**Re: Wyndham Hotel Renovations
Cutler Ave. / Carlisle Blvd.
Traffic Impact Study Comments**
Engineer's Stamp dated 6-04-2018 (H17D002)

Based upon the information provided in your submittal received 6-04-2018,
Transportation cannot approve the TIS for the above referenced project.

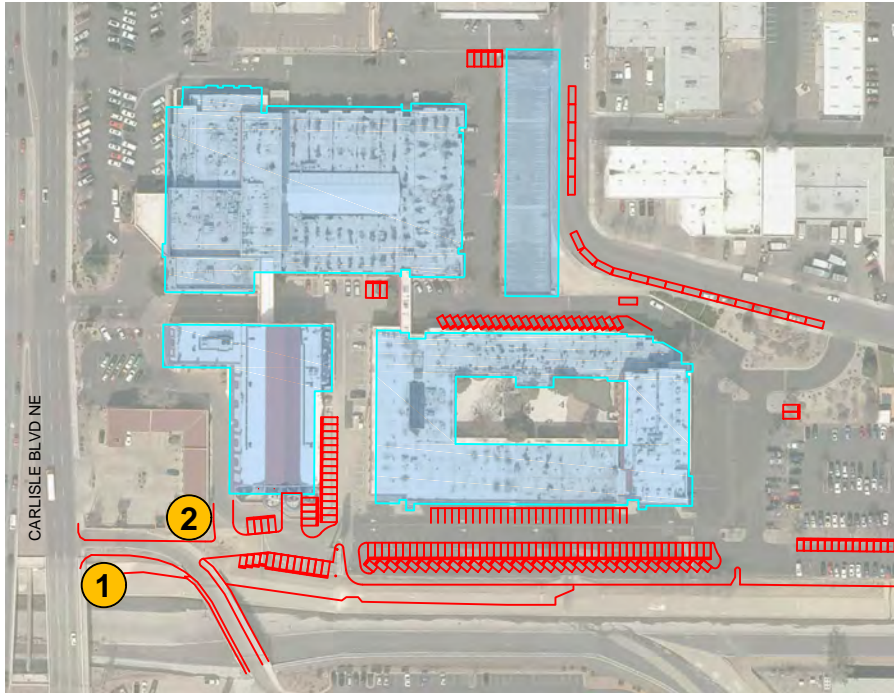
3. Page 10 – There is no explanation of what the numbers and letters in the lower right of the diagram represent. I assumed the letter was level of service and number was delay, but the delay number does not match what is shown on Page 9. Add to legend and cross check information.
